COMPLETED 10/11/07 SH  
**DRB CASE ACTION LOG (PREL & FINAL)**

DRB Application No.: 07DRB-70263 (P&F) SOE Project # 1006656  
 Project Name: MRGCD MAP # 37 #111111 JESUS F APODACA  
 Agent: ROSS HOWARD COMPANY Phone No: 897-0291

DEVELOPMENT REVIEW BOARD – SPEED MEMO

CITY OF ALBUQUERQUE  
Planning Department  
October 3, 2007  
DRB COMMENTS

PLAT OF
 LOTS "A" AND "B"
 LANDS OF
 JESUS F. APODACA
 SITUATE WITHIN
 CITY OF ALBUQUERQUE
 TOWN OF ALBUQUERQUE GRANT
 PROJECTED SECTION 17, T. 10 N., R. 3 E., N.M.P.M.
 BERNALILLO COUNTY, NEW MEXICO

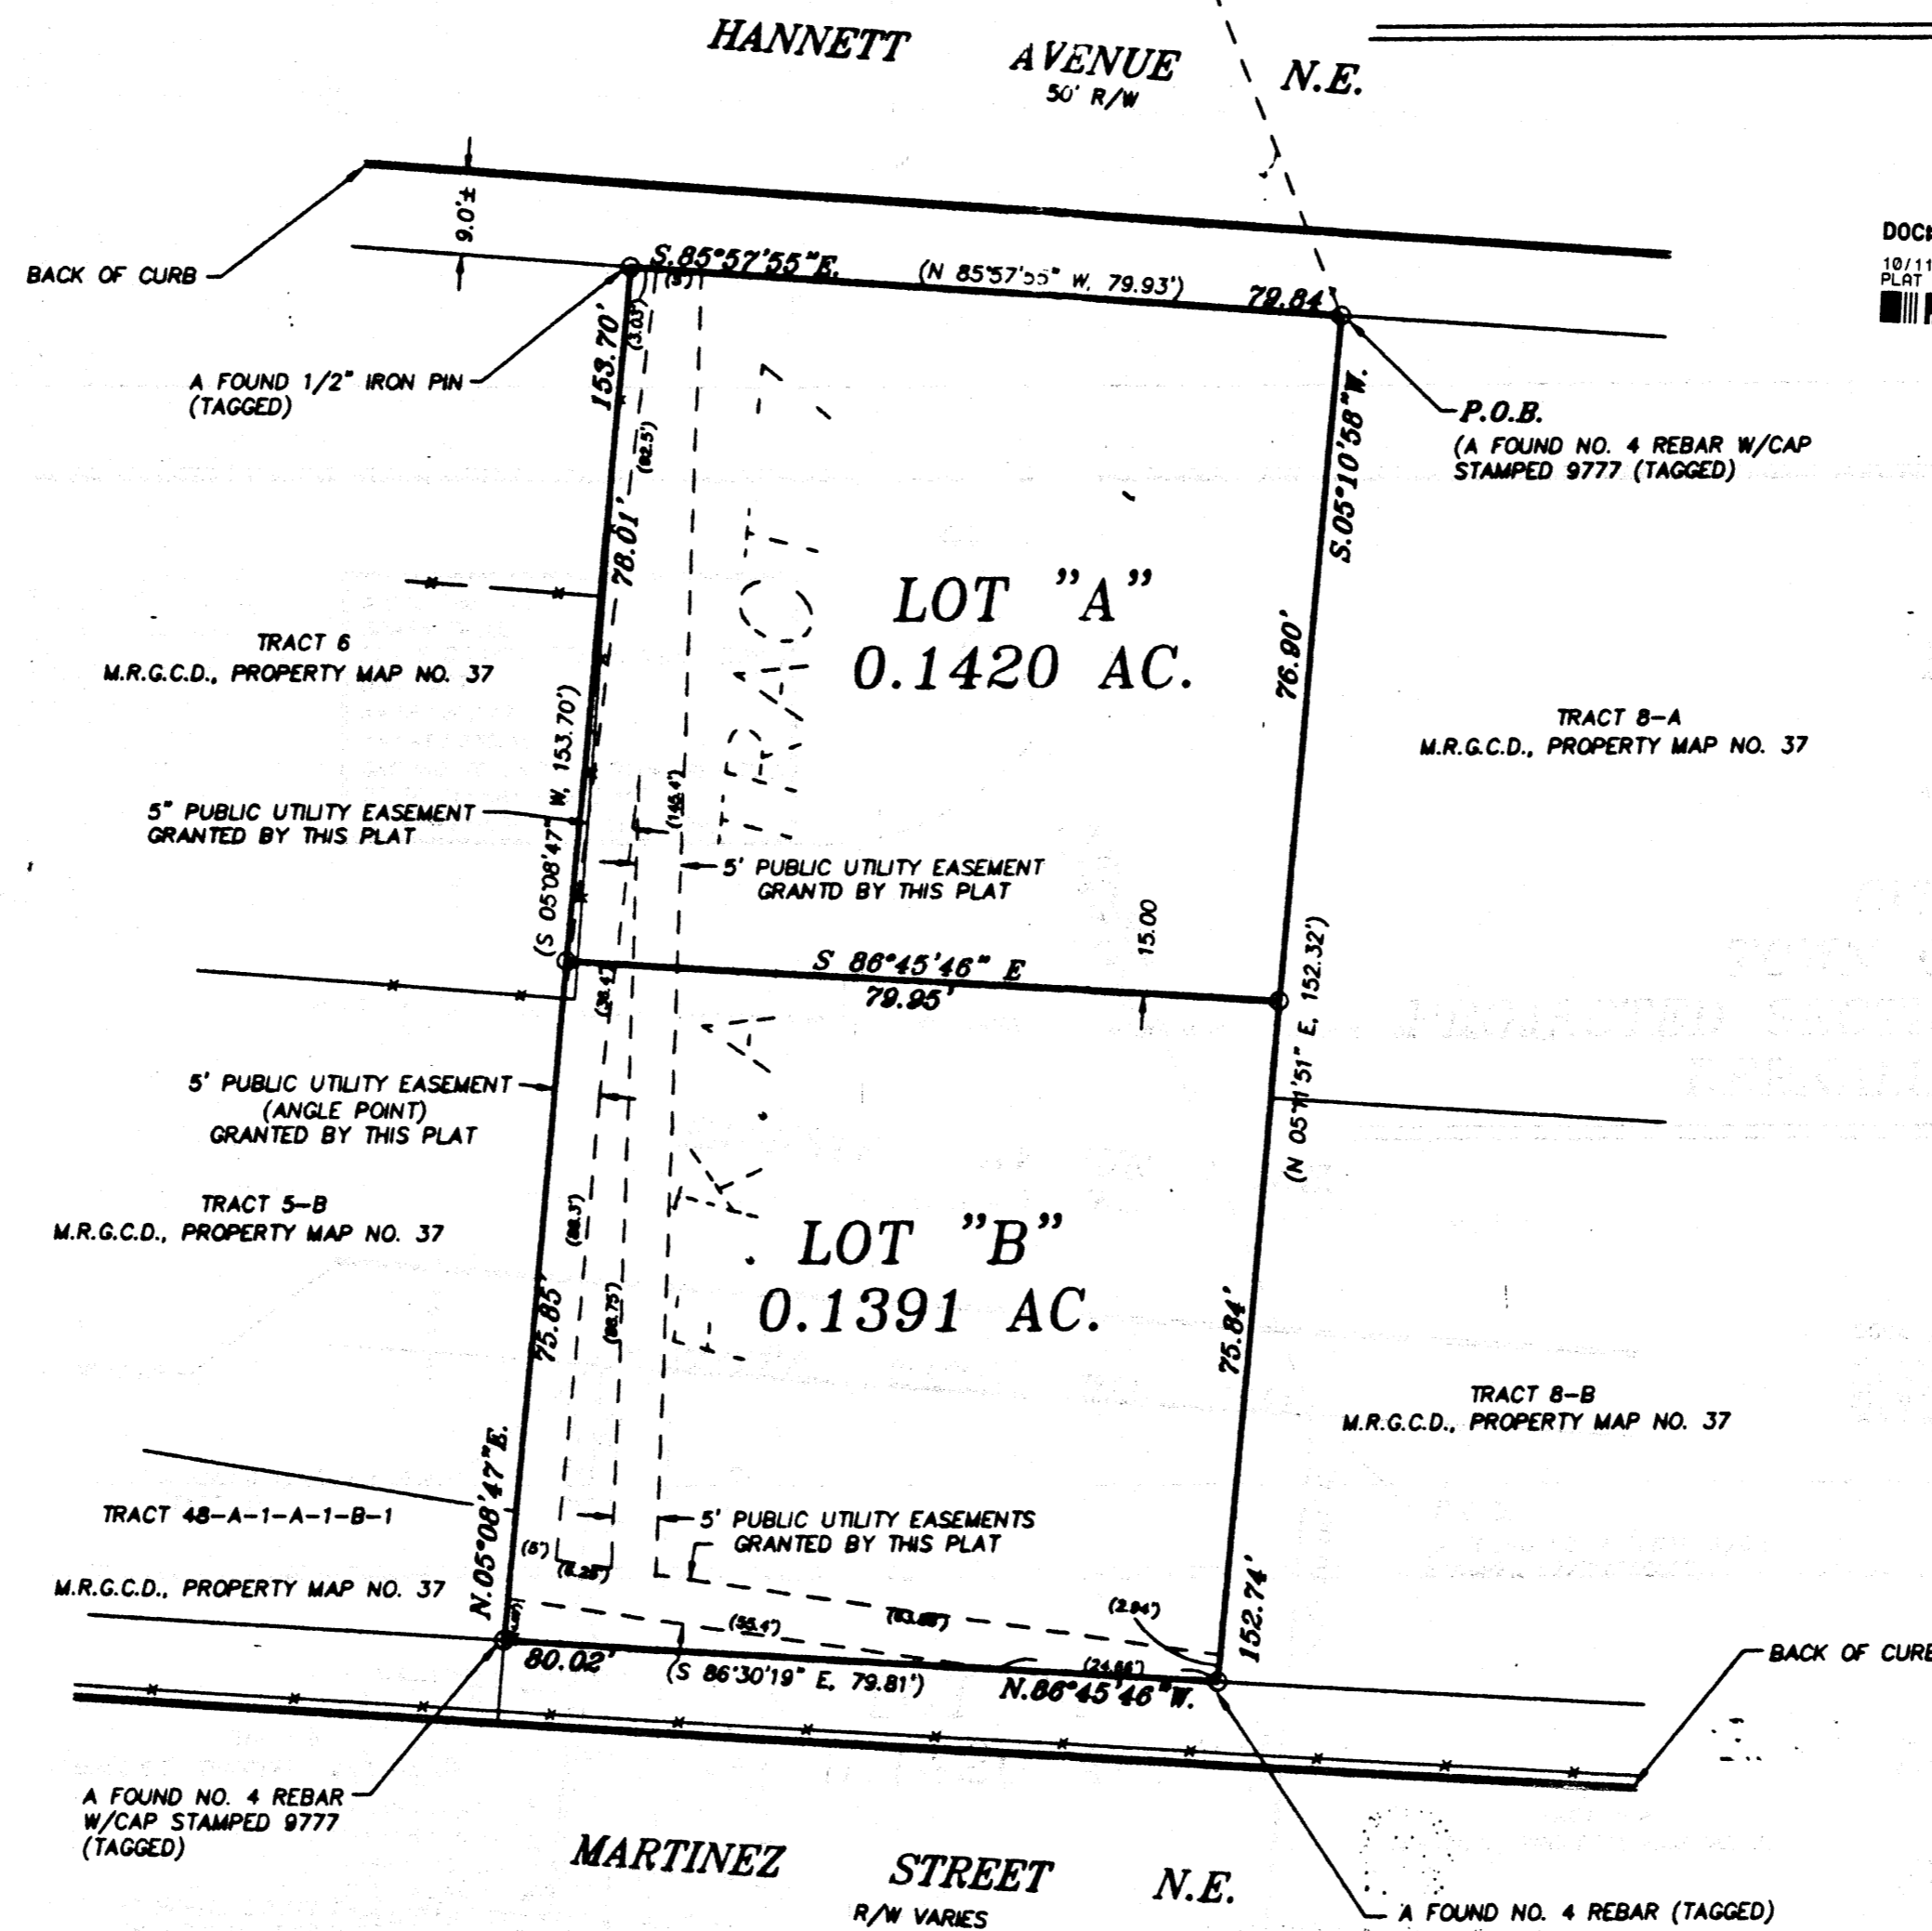
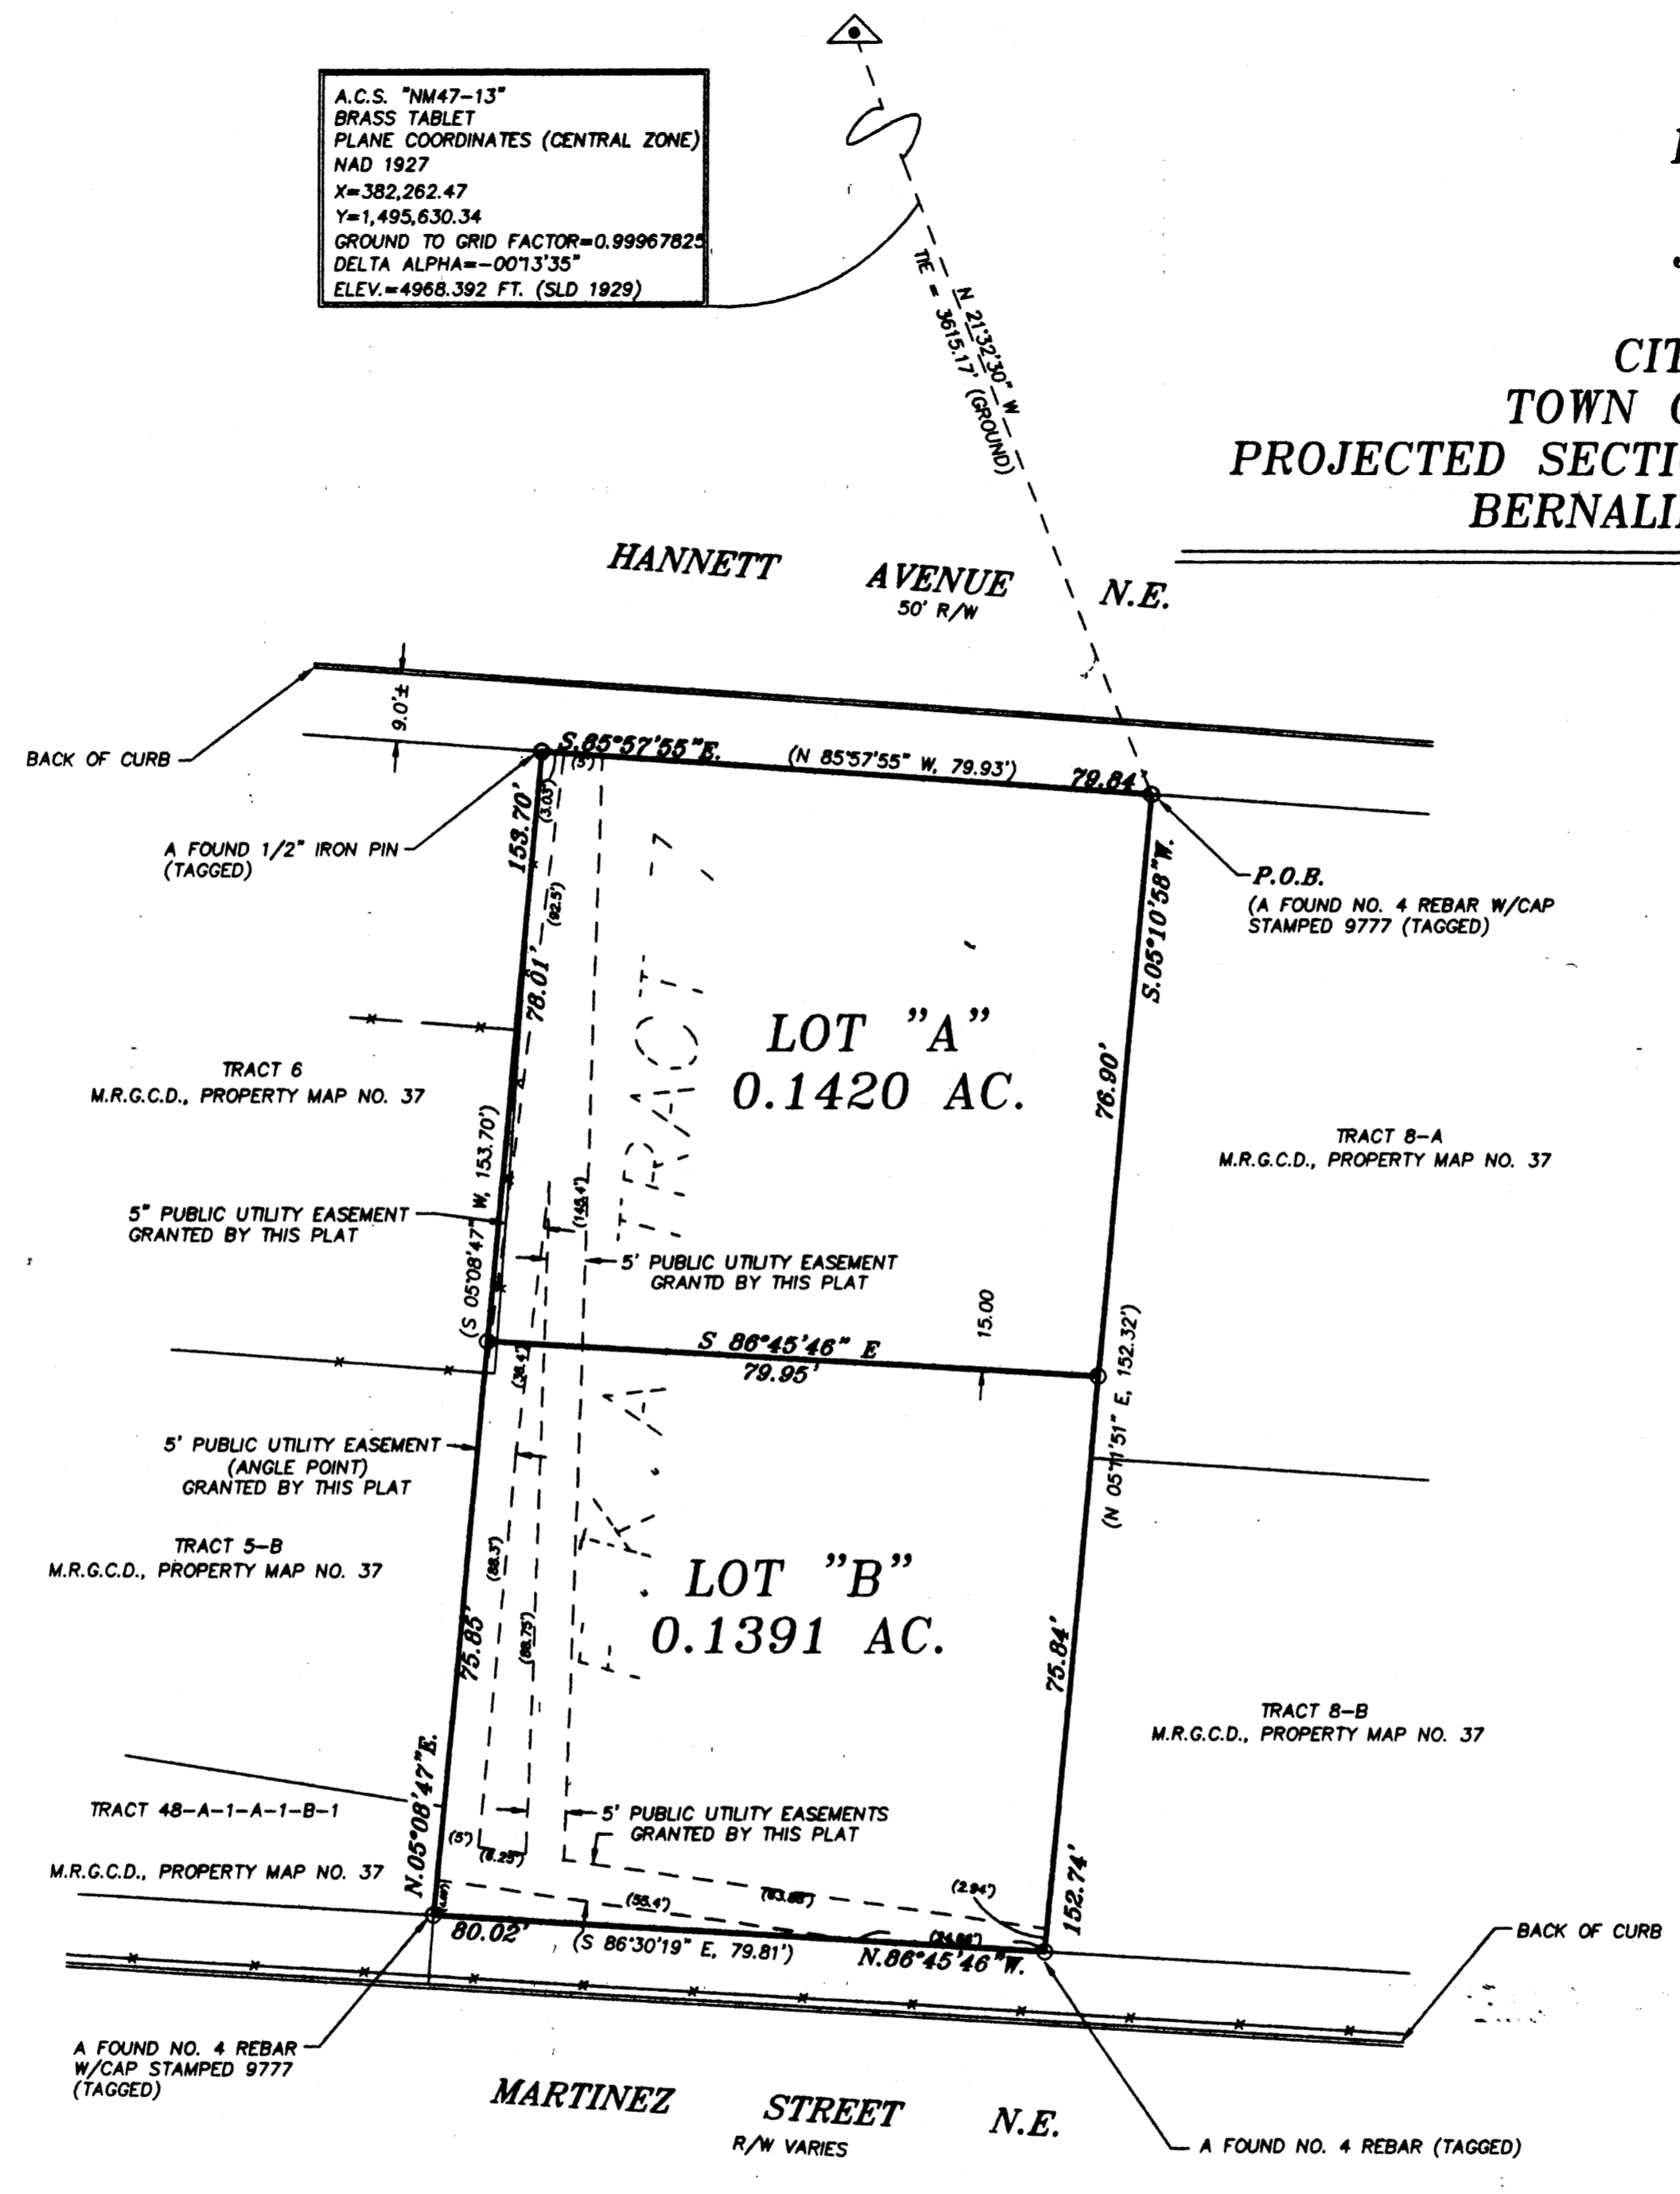
The AGIS dxf is not approved.

<u>No.</u>	<u>Comment</u>
1)	Standard infrastructure per the DPM is required.
2)	Cross section of both Martinez St. and Hannett Ave. are needed to evaluate possible dedications and improvements. The cross sections need to show the street width, sidewalk width and location, and the distance from face of curb to the property line.

Tract 7, the rear yard is not the 15 feet, as required in the R-1 zone of the Comprehensive City of Albuquerque Zoning Code.
